From: White, Joy - Communities <Joy.White@Oxfordshire.gov.uk>  
Sent: 08 September 2020 16:02  
To: Linda Griffiths  
Cc: Planning; Planning Consultations - E&E; Bbosa, Rashid - Communities  
Subject: 20/00811/OBL and 20/00812/OBL

TITLE: External Works Details	
PROJECT:	White Post Road, Bodicote
DRG. No:	957-06-01

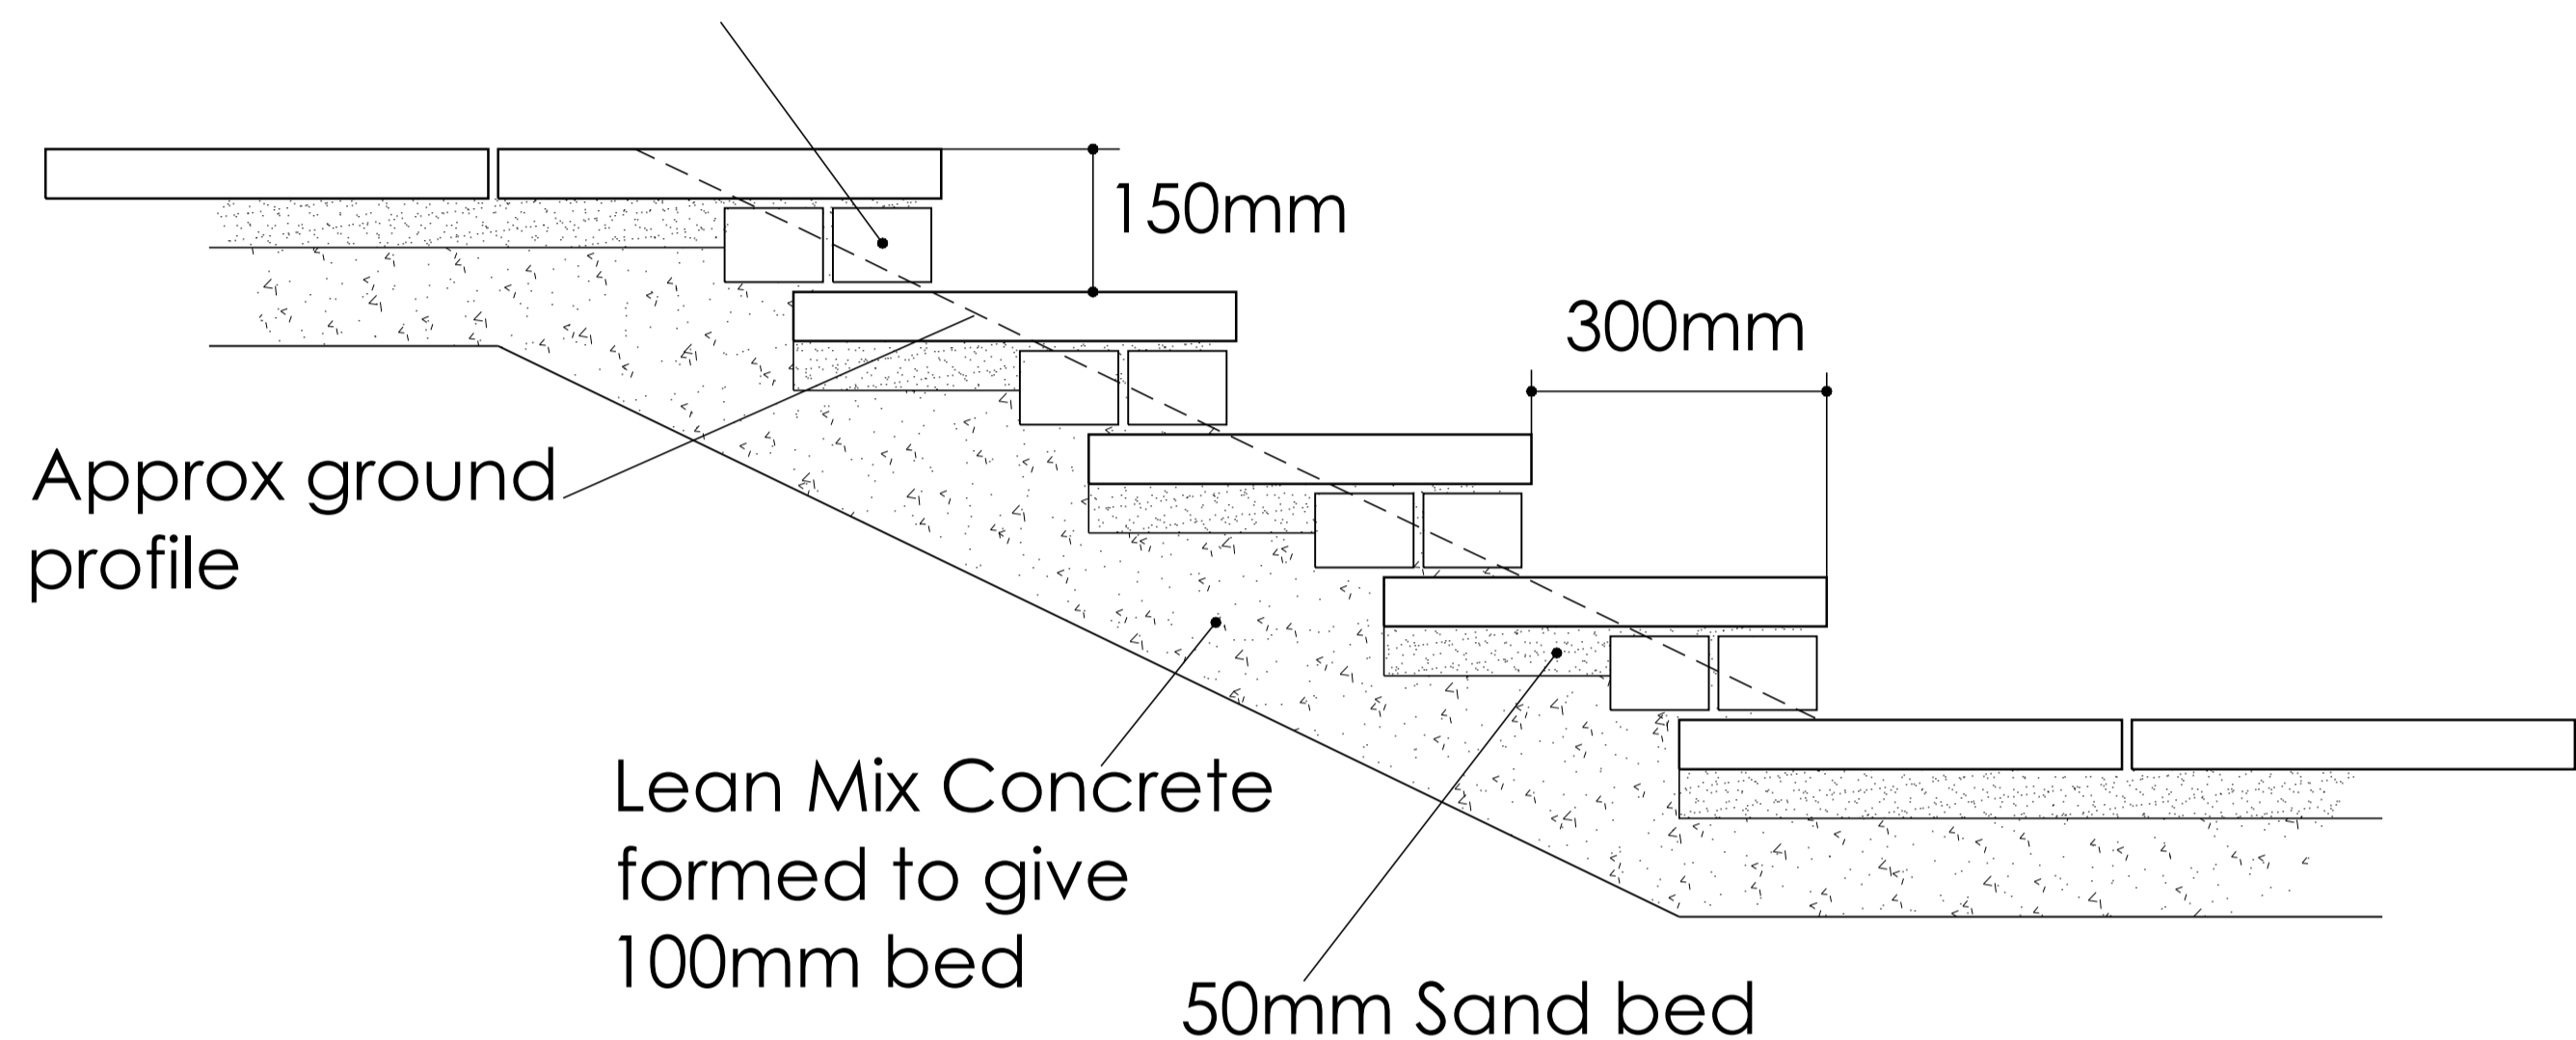
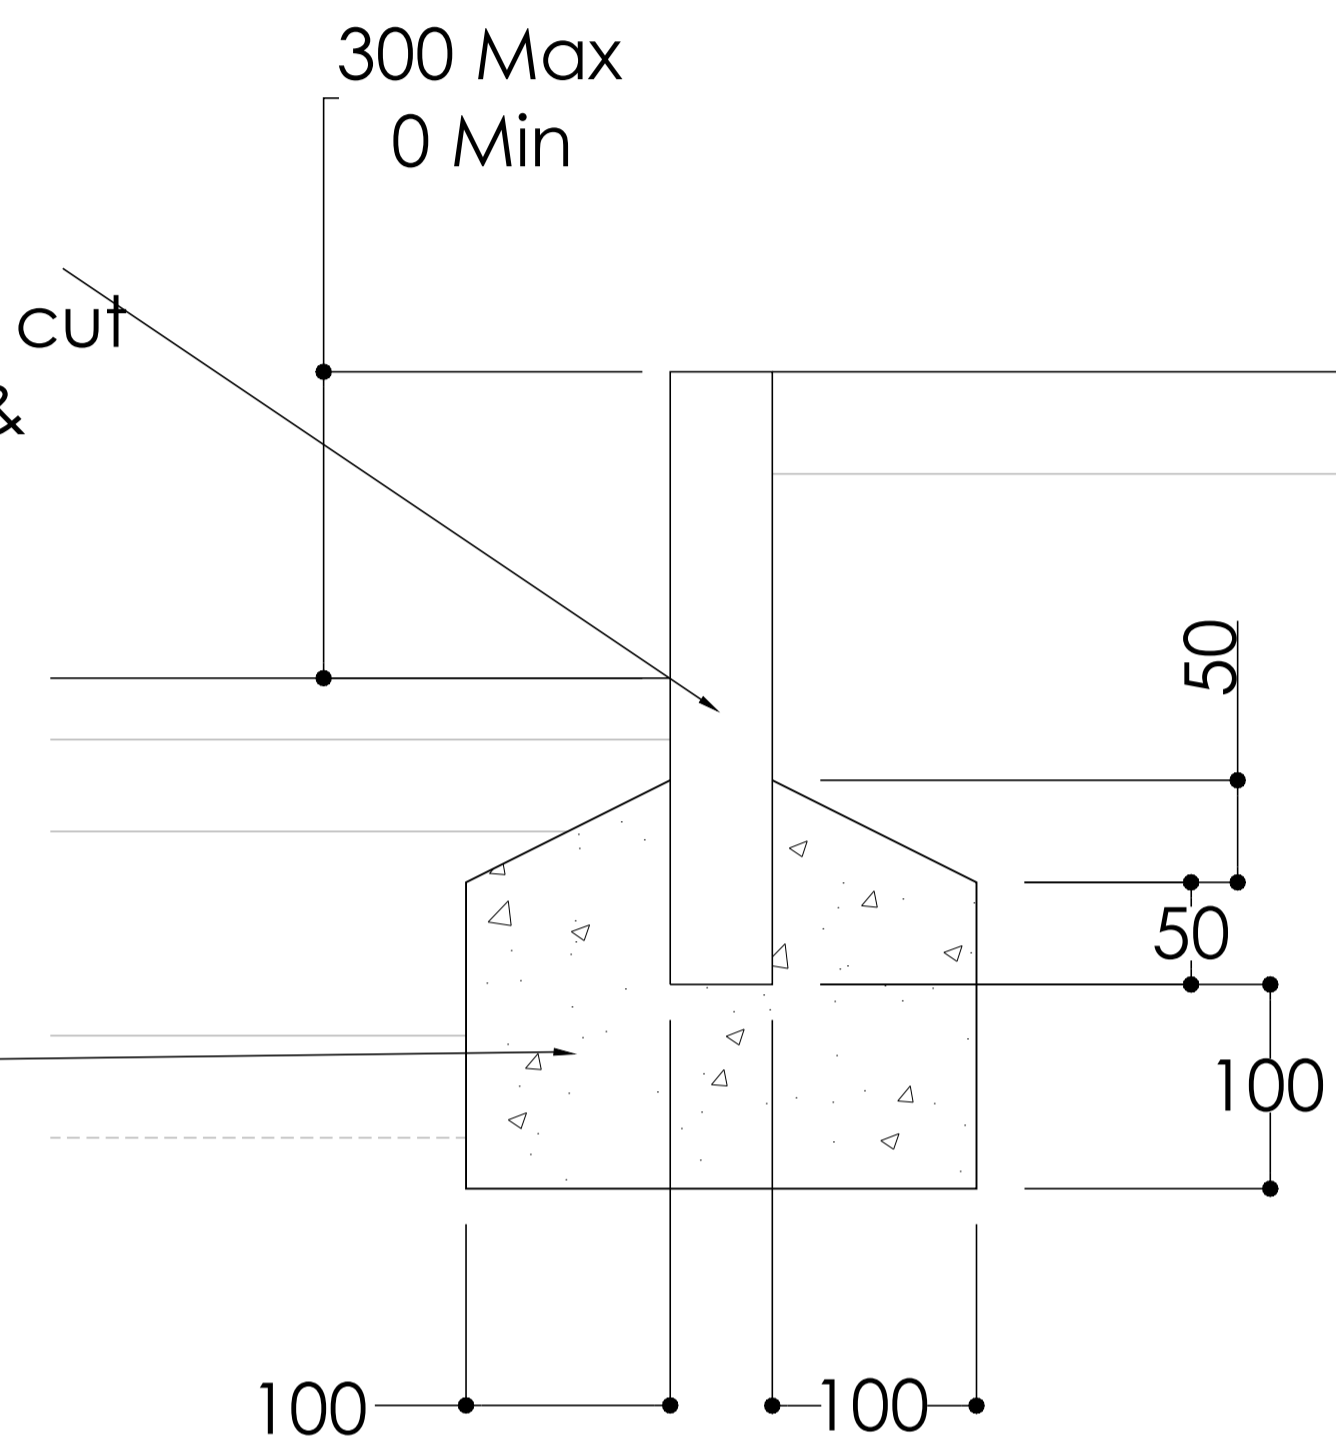
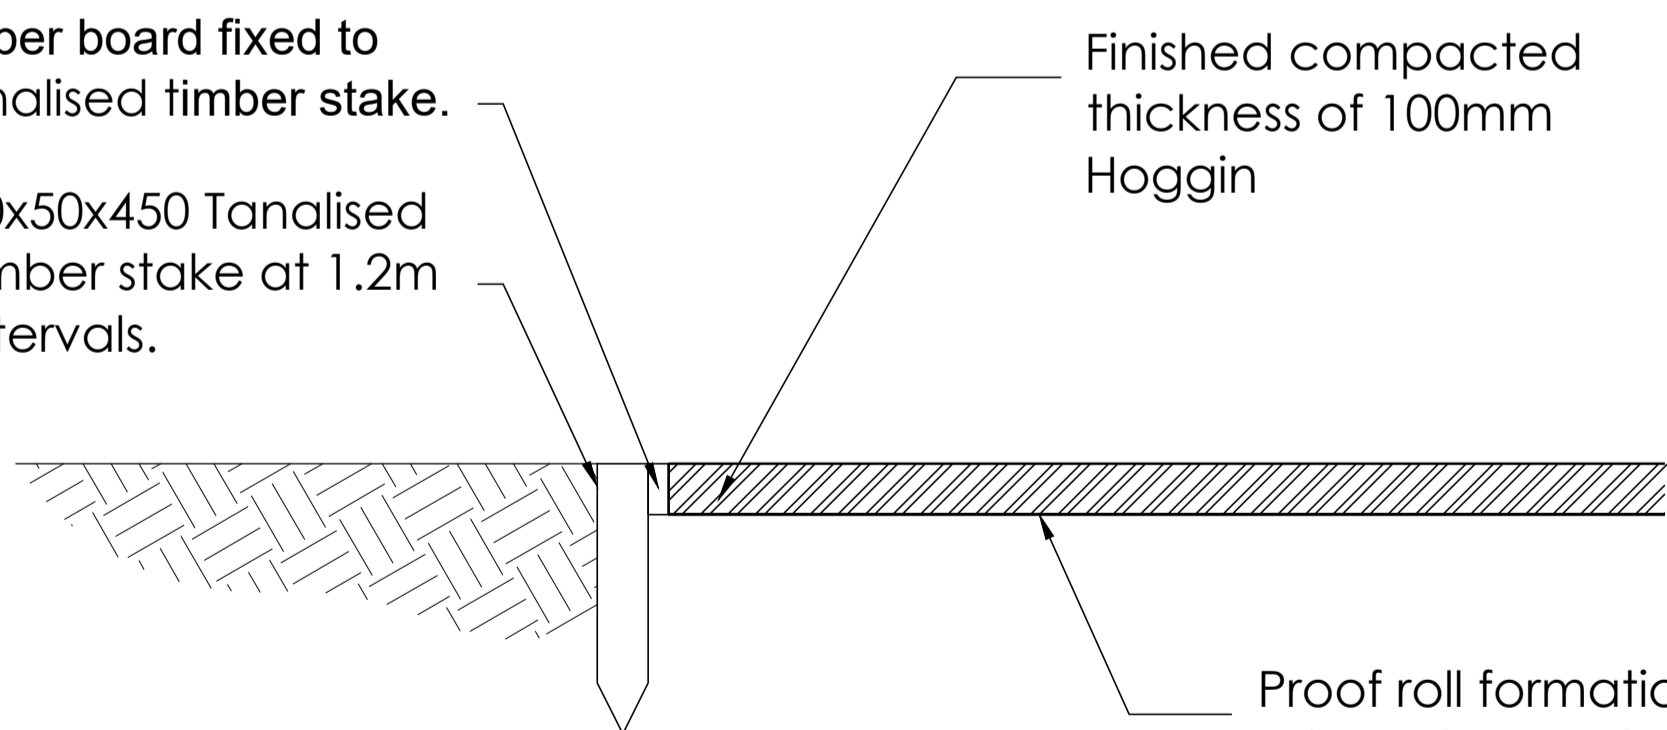
- The specification does not mention space either side of the bridleway. The applicant should refer to British Horse Society guidelines. 3m is very narrow for a path to be shared with pedestrians and cyclists, as is likely here - 4m is preferred.
- There is no detail of the crossing point over the spine road.
- There is a pinchpoint around the edge of the adult football field. Use by equestrians during a football game could be challenging!
- The maintenance regime does not specifically mention grass mowing and cutting of vegetation adjacent to the bridleway. Although this is probably picked up elsewhere, it should be included as a requirement of the bridleway maintenance.
